State of Washington
DEPARTMENT OF FISH AND WILDLIFE

August 26, 2022

SUBJECT: WDFW COMMENTS ON CU-15-00002 YAKIMA RIVER CAMPGROUND

YAKIMA RIVER SHORT PLAT - SP 15-XXXXX
 A PORTION OF THE NORTH 1/2 OF SECTION 4,
 TOWNSHIP 19 NORTH, RANGE 16 EAST, W.M.,
 KITTITAS COUNTY, WASHINGTON

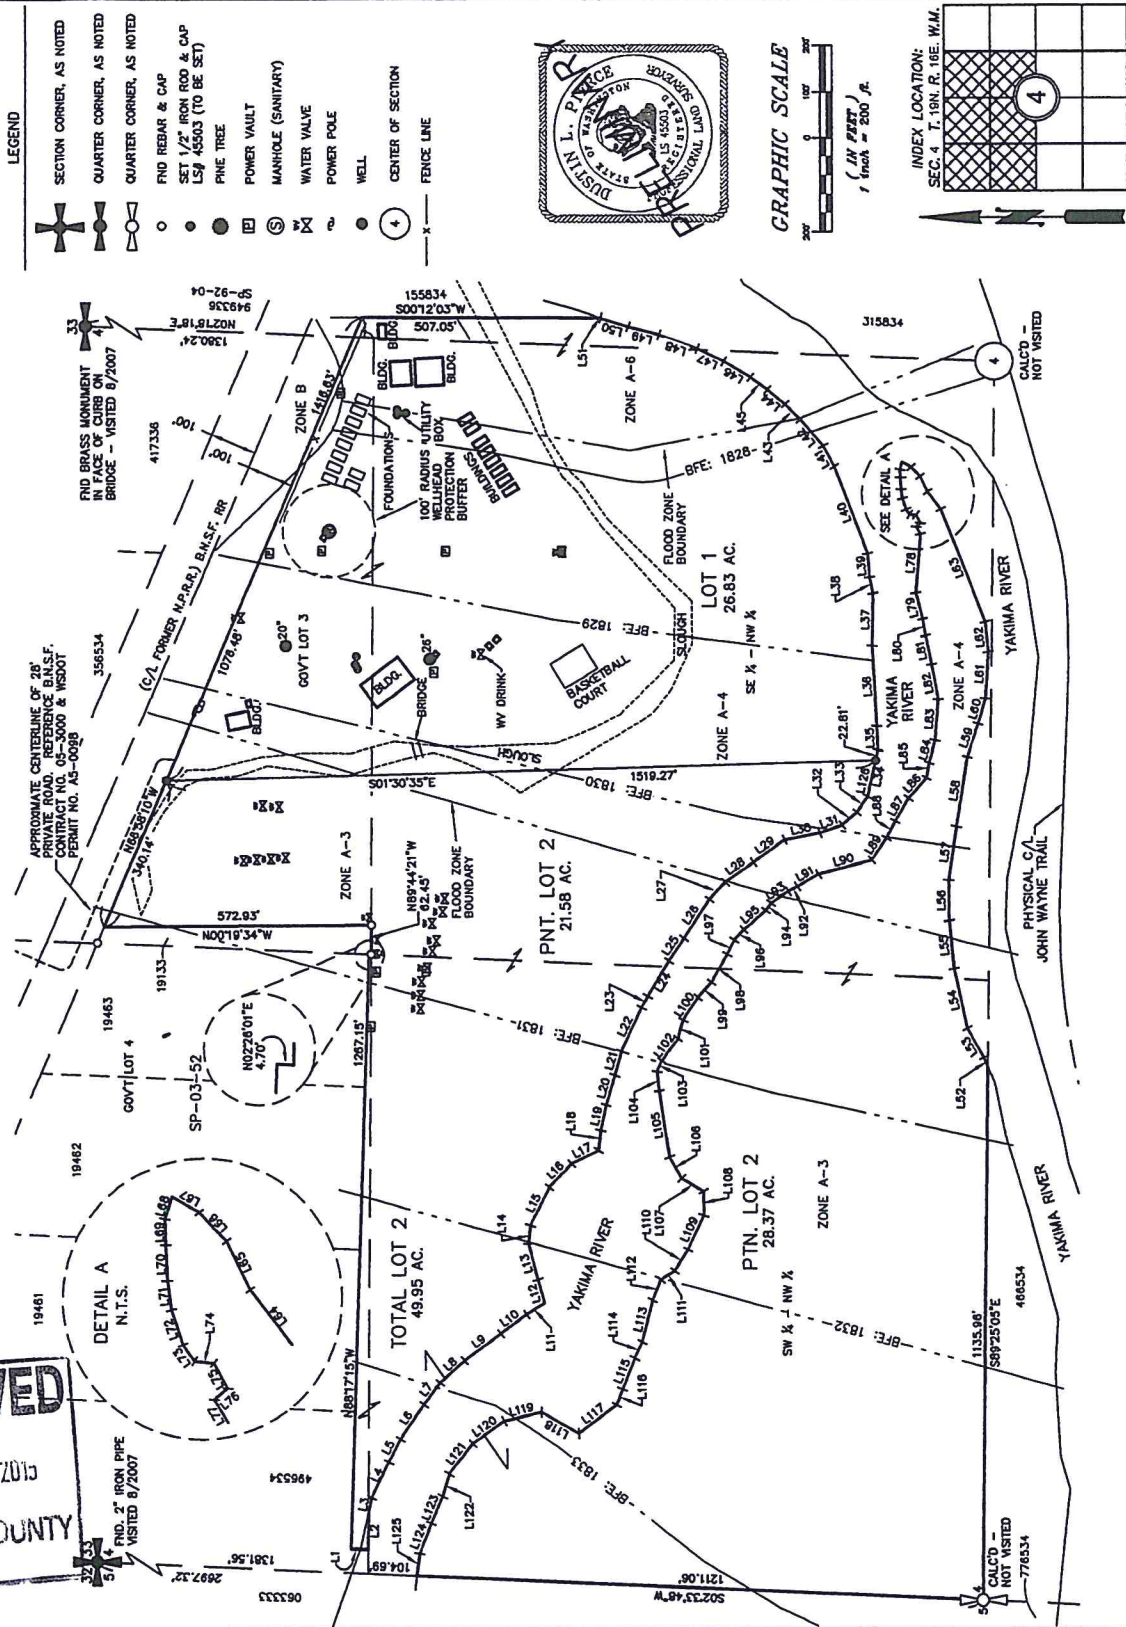
The proposed short plat to divide the property into 2 parcels is of concern to WDFW. The existing wetlands, side channels, CMZ, and floodway make development within this area quite challenging. The proposed short plat divides the property into parcels that will likely require variances and exceptional treatment for development by future landowners. If the short plat is simply a tool to vest the applicant's proposal in the outdated 1975 Shoreline Master Program, rather than the updated 2016 SMP, it seems to defeat the intent and purpose of the Growth Management Act and the Shoreline Management Act.

If necessary, we suggest drawing the short plat lines differently such that the slight terrace where the existing buildings are with minimal vegetation is one parcel and the remaining lower elevation forested and floodplain is the second parcel; it could be placed in a conservation easement to protect it development in perpetuity while providing a tax incentive to the owner. A draft concept of this is provided in the enclosure.
